Planning Application Ref: Y/98/18/RES

Location: Land off Burndell Road, Yapton

Description of works: **Approval of reserved matters (access, appearance, landscaping, layout and scale) following outline permission Y/19/16/OUT for 108 residential dwellings, with associated parking, road/footway/cycleway provision, open space, landscaping, surface water attenuation and ancillary works**

scheme: Burdell Road
Yapton
client: Bovis Homes (Southern Counties)
drawing: Tree Protection Plan
date: November 2018
scale: 1:500@A1
dwg no: BOV22172-03A
drawn: MW checked: TRG

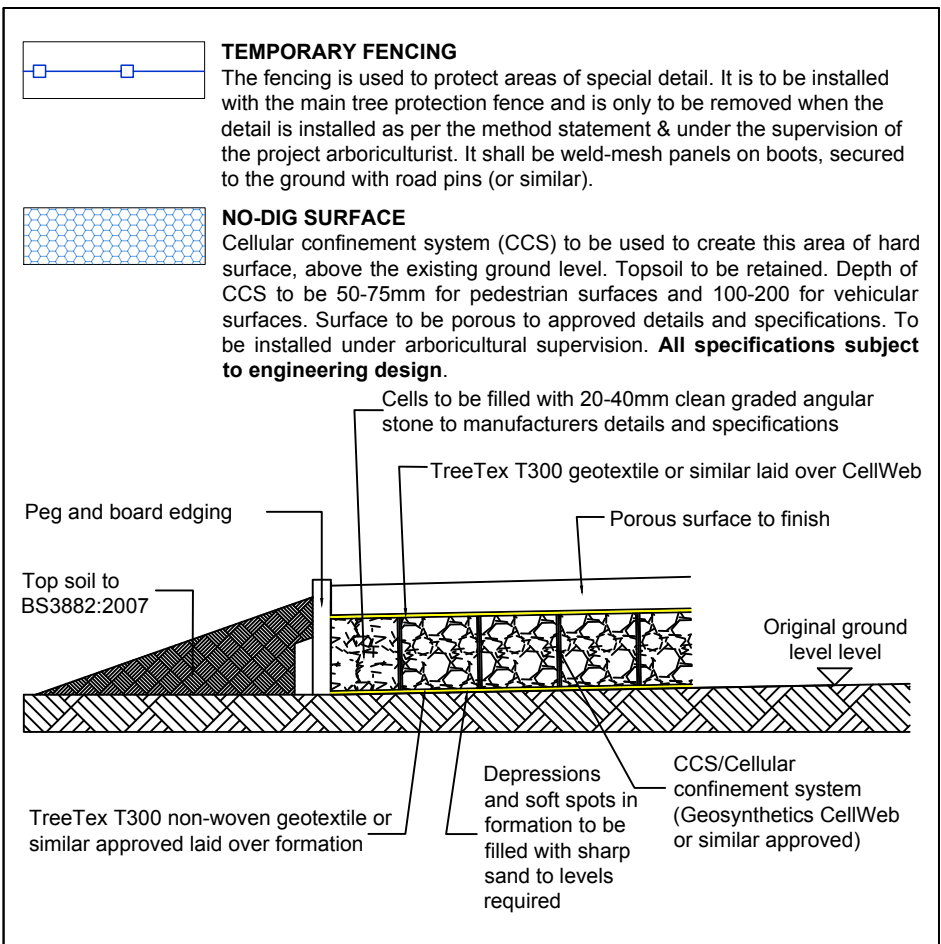
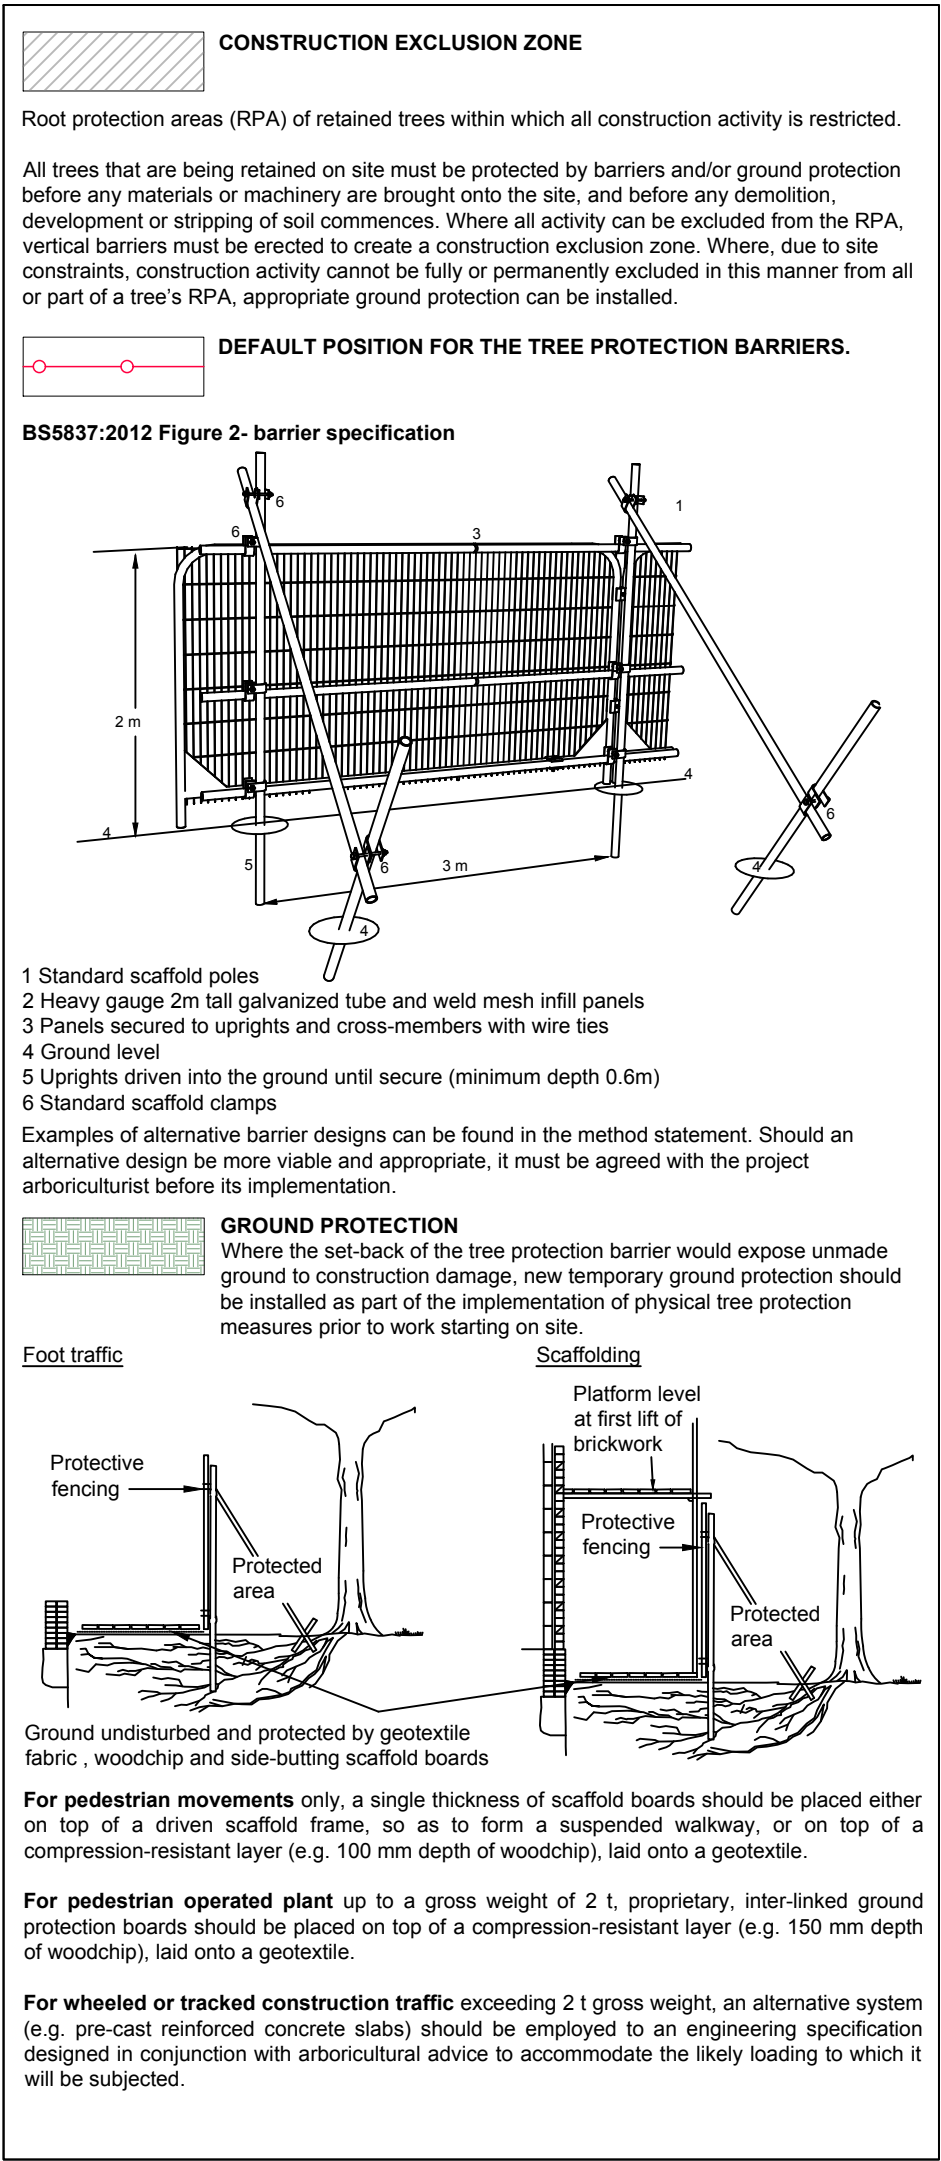
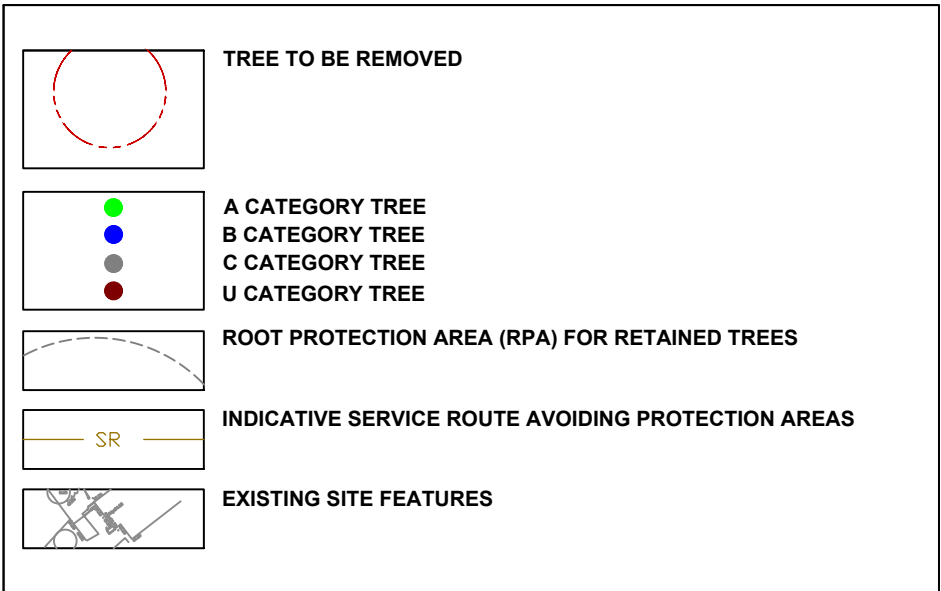
- In support of this reserved matters application, the applicant (Bovis Homes) has employed ACD Environmental to submit a Tree Protection Plan (TPP).
- The TPP shows a typically ambitious layout but with inadequate regard and respect for the few perimeter trees of significant landscape and amenity value.

- The current proposed layout is going to impact on four significant oak trees (G10 and T7) both above and below ground.
- In respect of G10, the proposed attenuation pond intrudes on the root protection area (RPA) of one mature oak, a tree with growth potential and the roots from which will extend beyond the ditchline. This potential conflict is avoidable and should be designed out.

- In respect of T7, significant RPA intrusion is proposed during construction of parking bays. Although achievable in principle by adopting the tree protection measures proposed (No-dig construction); there is nonetheless a risk that attaches during such extensive incursion of root protection areas. This is especially significant where the tree(s) in question are by far the most important locally. This conflict would seem to be easily avoidable by re-locating two of the unallocated/visitor parking pays and so should be designed out.

- The proposed layout carries an avoidable risk of damage to significant trees of high landscape and public amenity value. An alternative layout that better respects those trees appears to be achievable without imposing any significant constraint on the development.
- I anticipate a revised layout being submitted that is more sympathetic to G10 and T7, to which I could lend my support. [The TPP has been updated and amended, which supports a layout that better respects those trees such that I can now lend this scheme my support.](#)

- As it stands, I must register an OBJECTION to the current layout proposals. I am now able to remove my objection and recommend **APPROVAL** for this scheme, subject to the following conditions being applied:

- Before the site is occupied or any machinery is introduced to the site or demolition work or construction work or alterations to existing ground levels takes place a **PRE-COMMENCEMENT Site Meeting** is to take place between the Arun DC Tree Officer and the Arboricultural Expert representing the site owners – at this meeting all protective fencing will be inspected along with ground protection measures – they will be assessed to verify that they are ‘Fit for Purpose’ as required under British Standard 5837:2012 and have been erected and positioned exactly as shown on the **Tree Protection Plan dwg. no. BOV22172-03D, dated November 2018**.
